# KIRKLEES METROPOLITAN COUNCIL INVESTMENT & REGENERATION SERVICE

### DELEGATED DECISION TO DETERMINE APPLICATIONS FOR CONSENT, AGREEMENT OR APPROVAL REQUIRED BY CONDITION

| <b>Site Address:</b>         | Land at, Penistone Road, Fenay Bridge, Huddersfield, HD8 0AW                                                                                                                                                                                                                                                                                          |
| <b>Description:</b>          | Discharge of details reserved by conditions 20 (surface water discharge), 21 (flood routeing) and 31 (grass-crete and batter maintenance) of previous permission 2022/93154 for erection of 68 dwellings with associated access, parking, open space, landscaping and infrastructure works (including installation of surface water attenuation tank) |

Headwall HW1

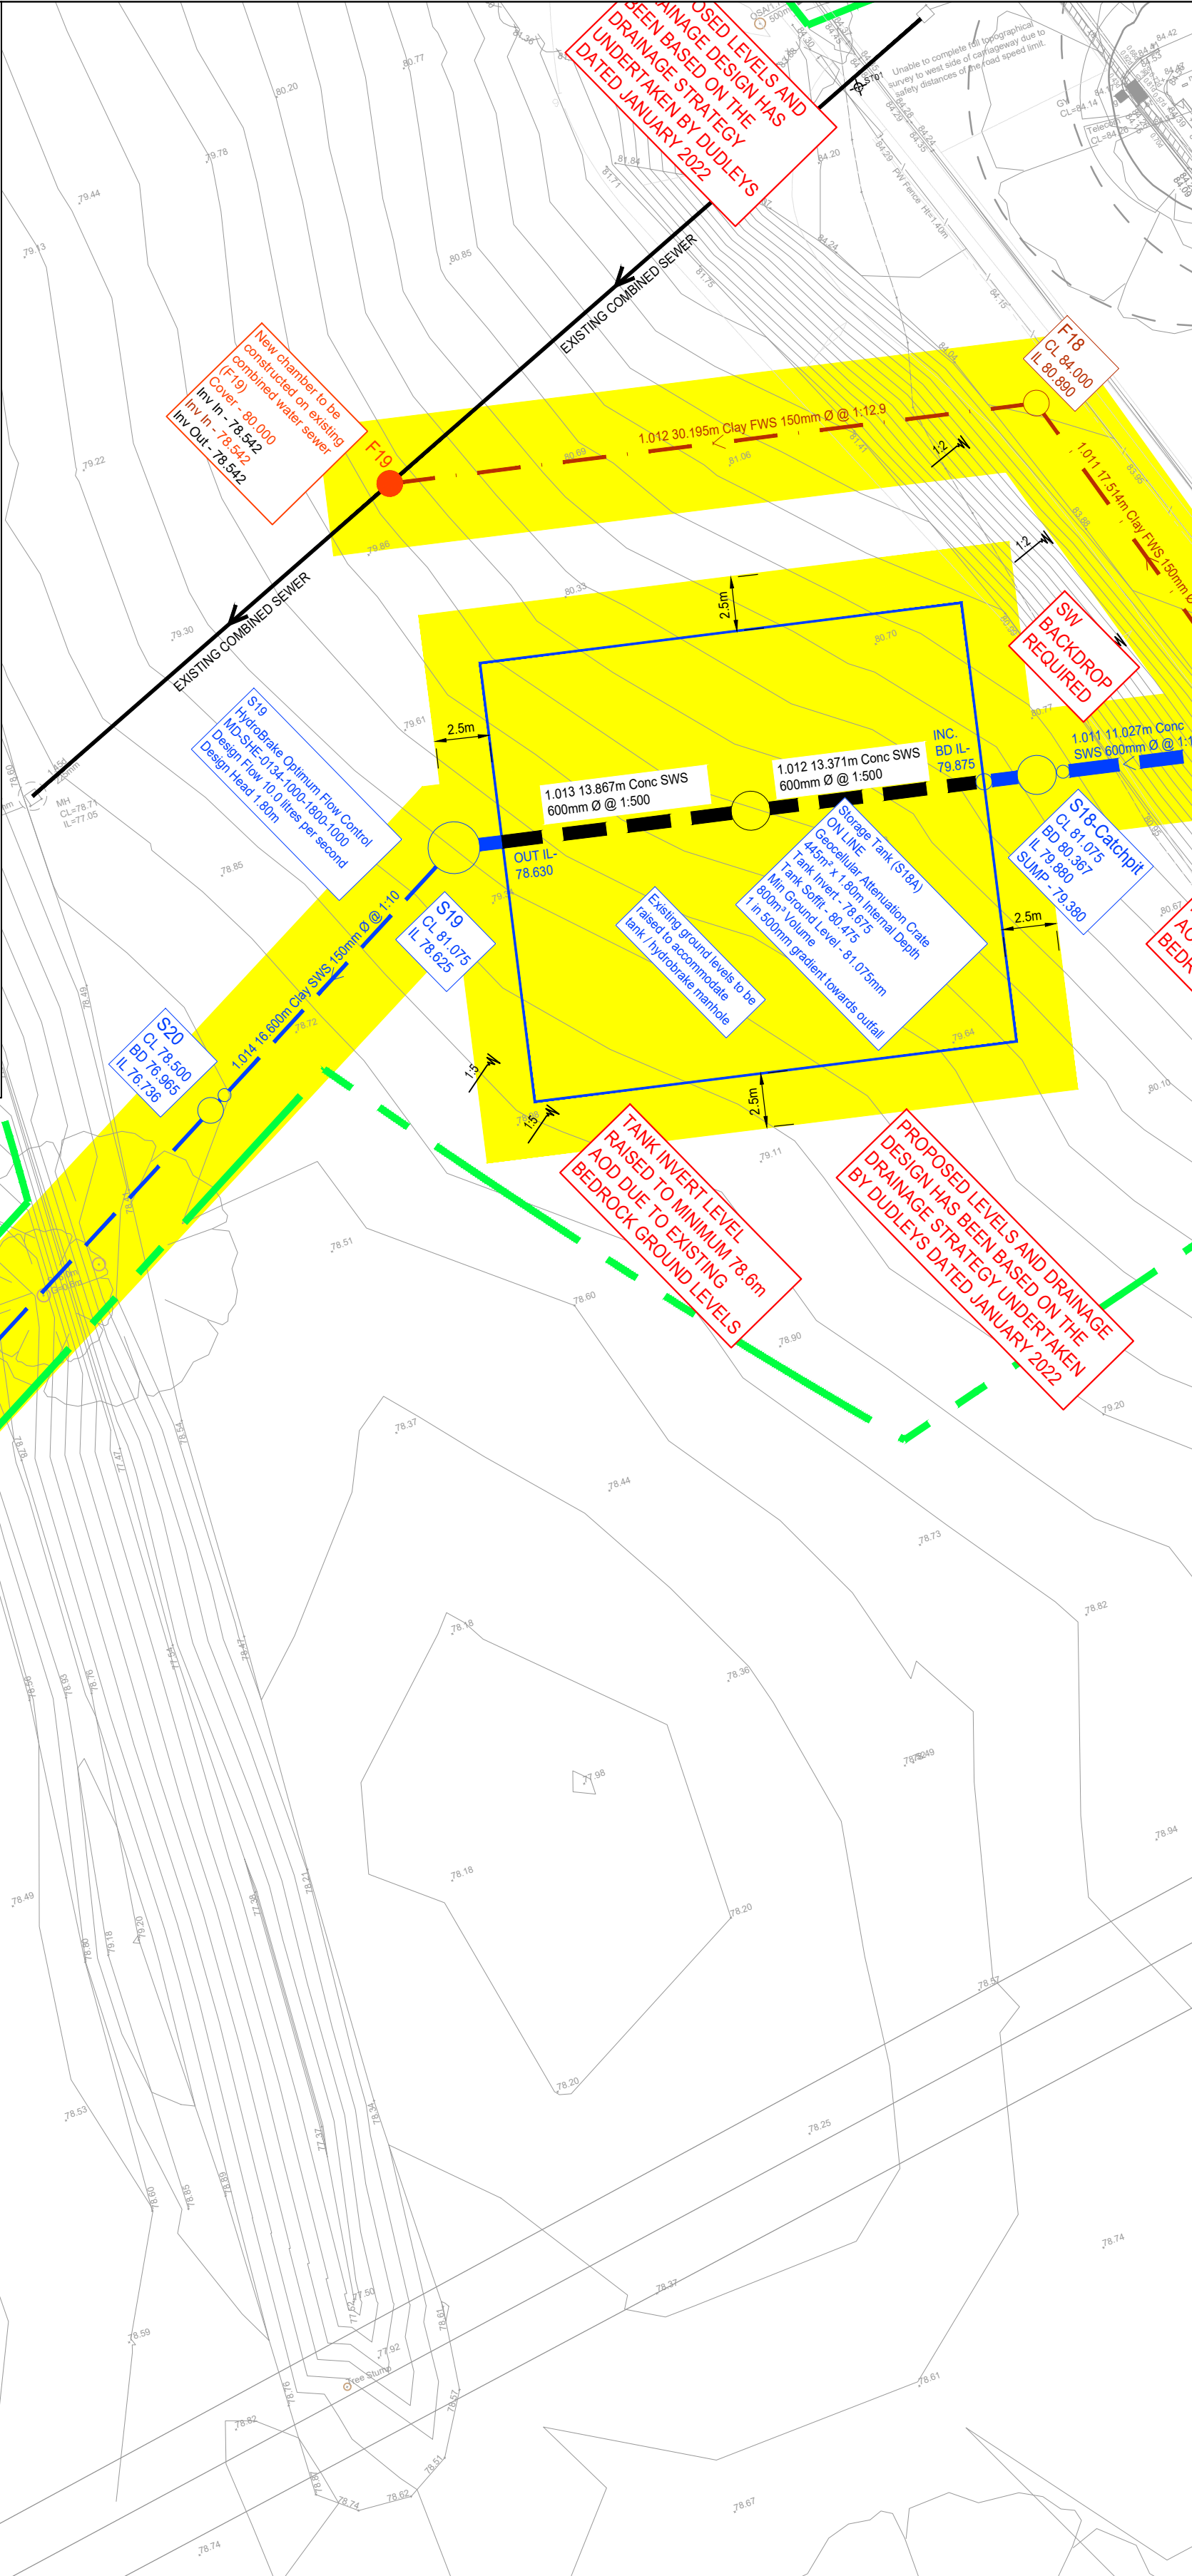
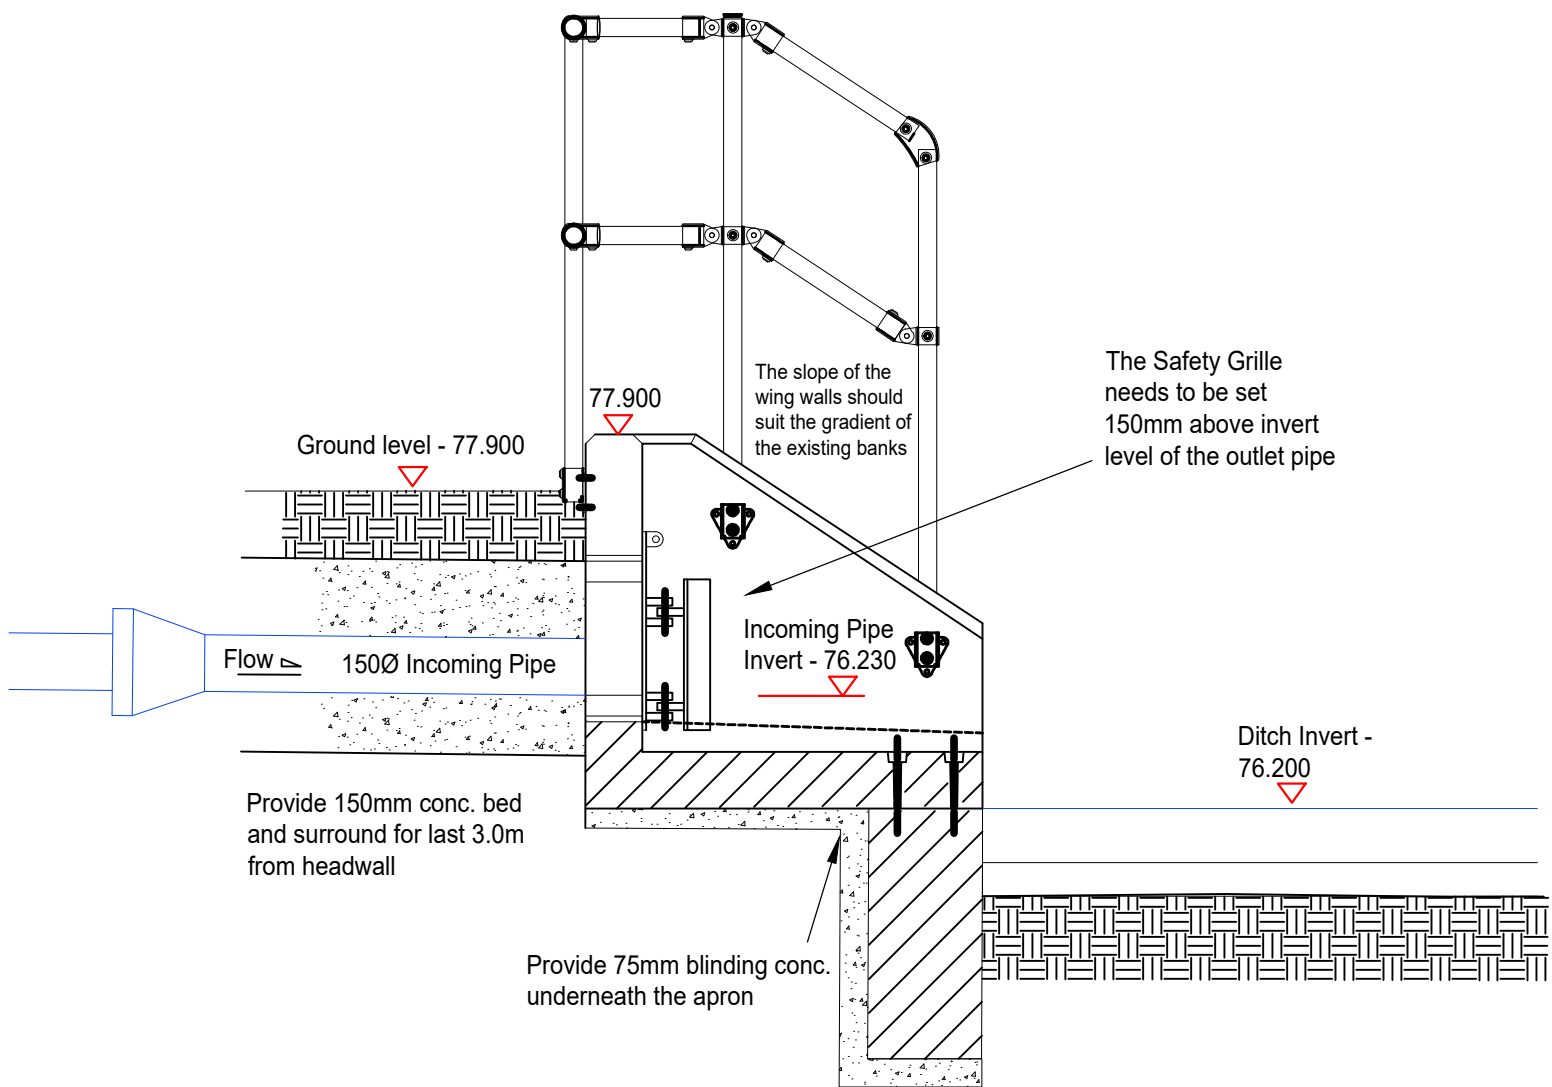
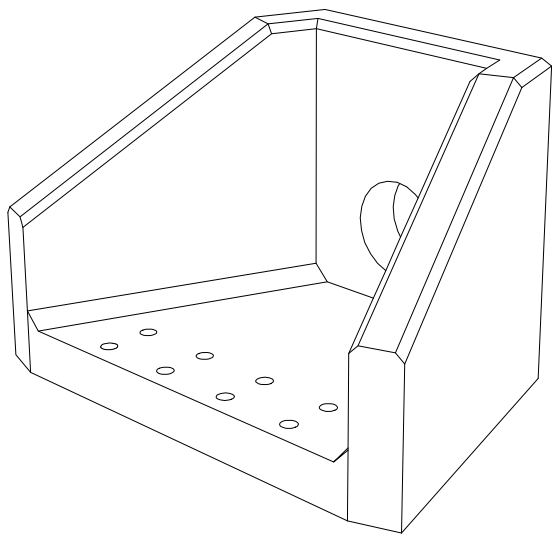
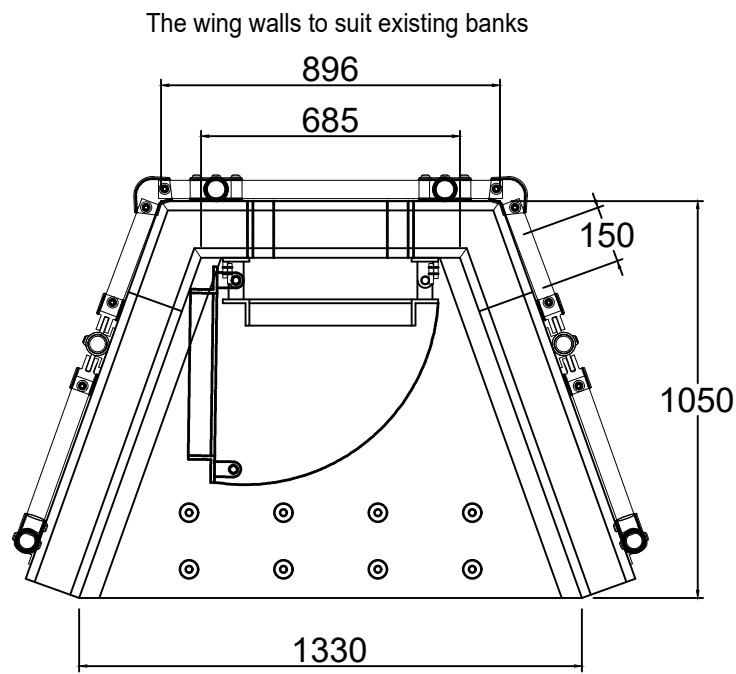
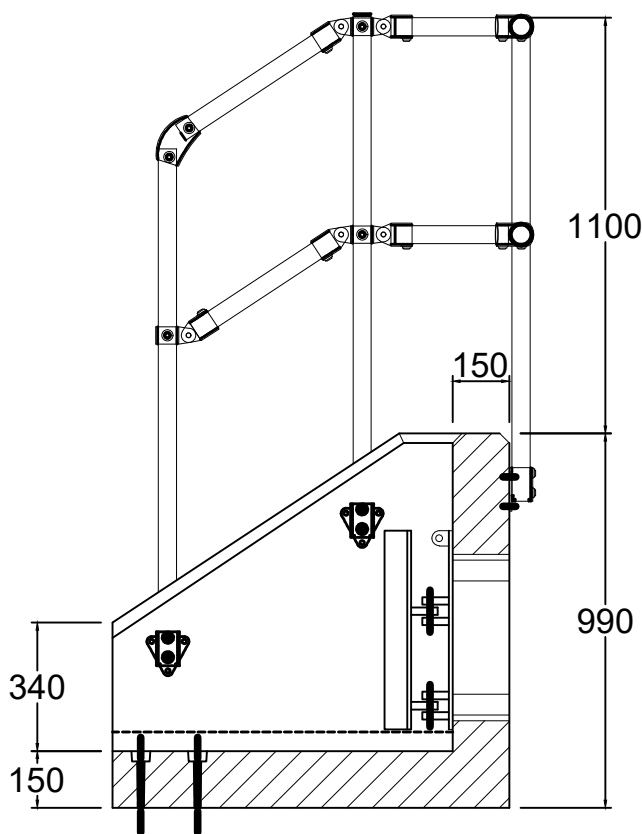
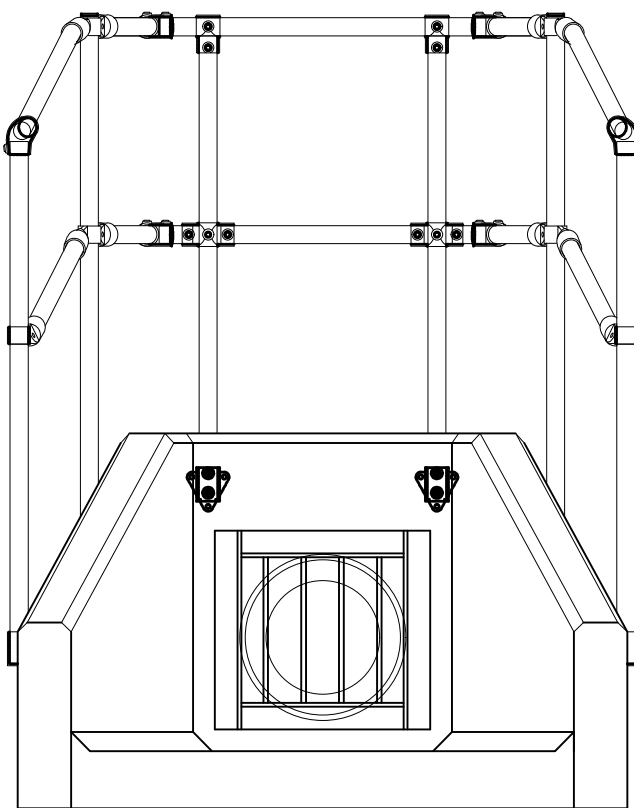
*Clarification of the outfall details are required. 150mm above existing typical water level is required. There is reference to only 30mm above ditch level. Connection should be to a watercourse. A safety grille is mentioned where a flap valve should be provided. We are concerned given the level above bed level, that this valve could be shut more often*

*than is desirable. A separate submerged outfall simulation is required. An addition spill inspection chamber prior to the outfall may be required.*

*A revised headwall drawing has not been submitted.*

*Outfall details have been received and are accepted.*

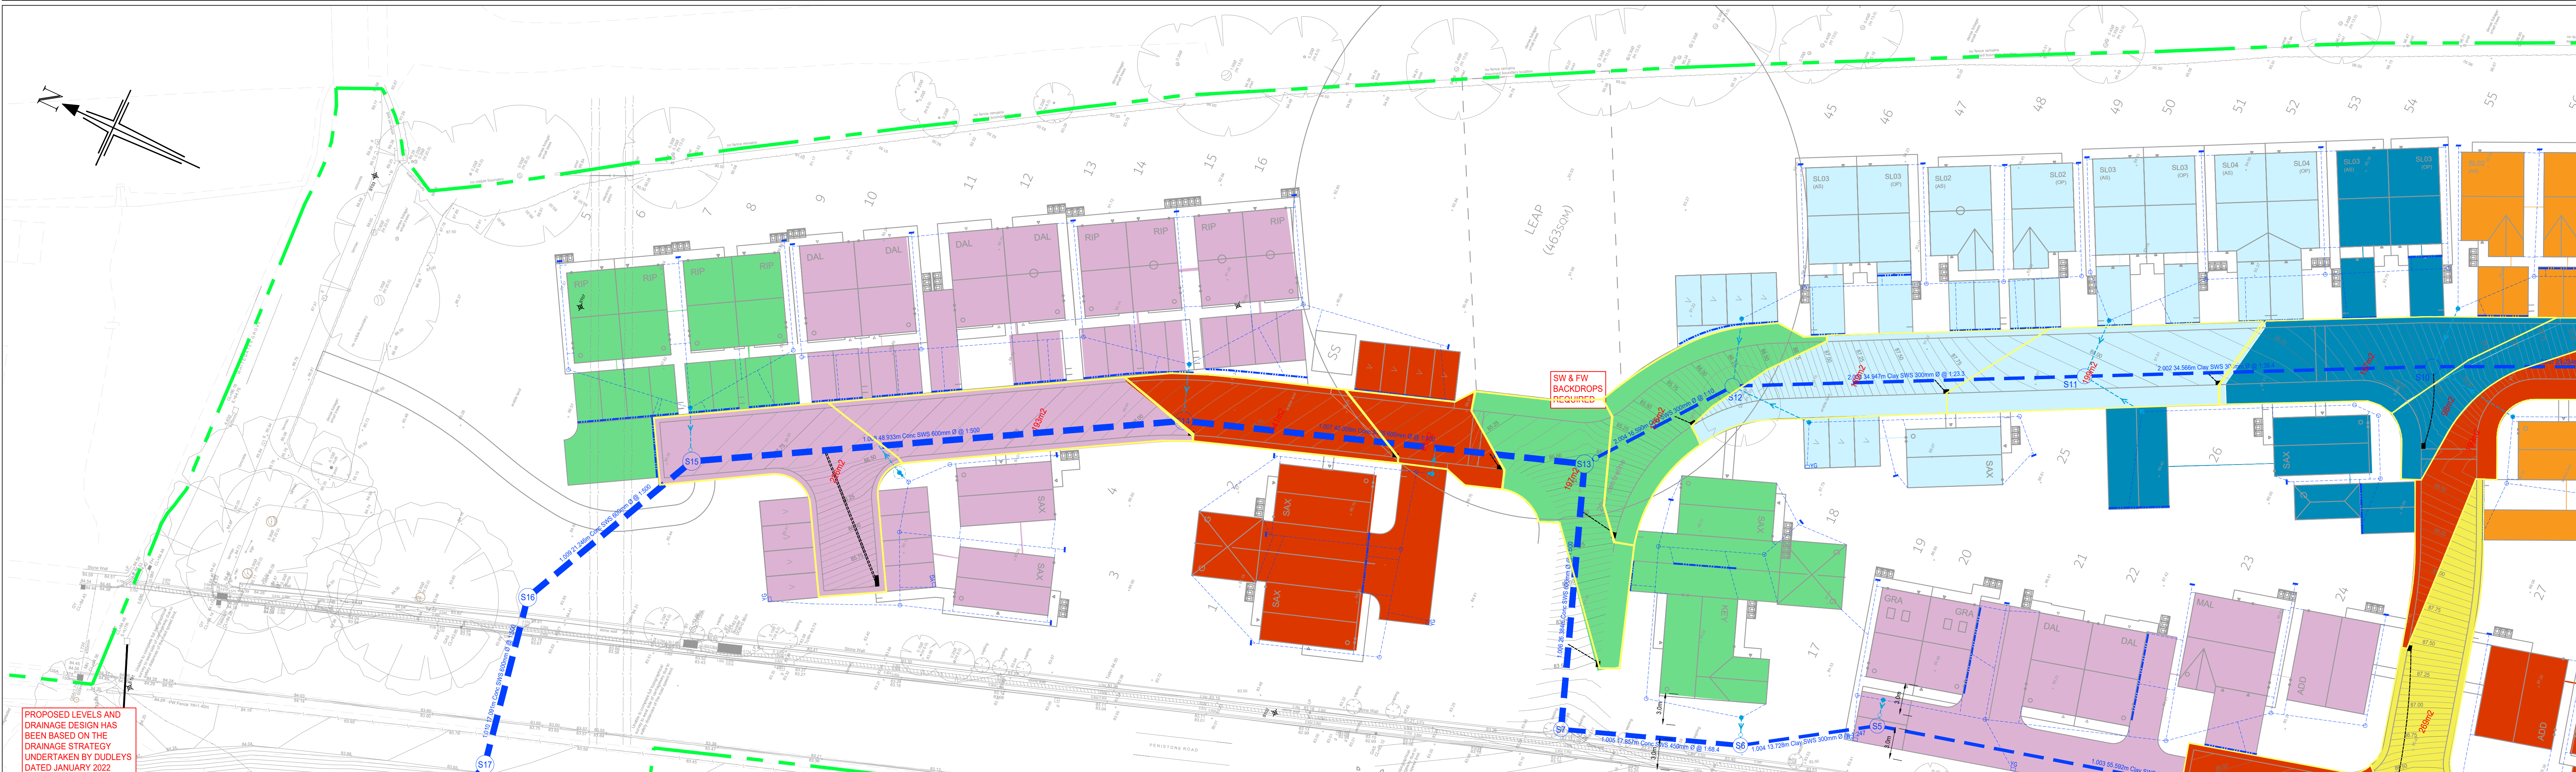
*However, there are multiple discrepancies between the measured hard standing area noted on an impermeable area drawing and those listed in the hydraulic design model.*

*In addition to the above, the impermeable area drawing is erroneous. As an example, around the green shaded area for road network and plots 17 and 18. Both the key and the hydraulic model show no hardstanding contributing to 1.005 (S6 to S7). However, the drawing showing private drainage layout clearly shows the majority of the plot's area draining to this very leg. Both plots are coloured green, but part is connected to 1.004 (S5-S6) and the roads of the same colour drain to 3 different legs of sewer not 1.*

*A clear check of all drainage should be made before resubmitting new impermeable area plans with key and update hydraulic modelling.*

*Further to our comments of 17<sup>th</sup> April 2025 and subsequent submissions for drainage. I can confirm that various discrepancies between drainage layout plans, hardstanding contributing areas and simulation modelling, have been ironed out.*
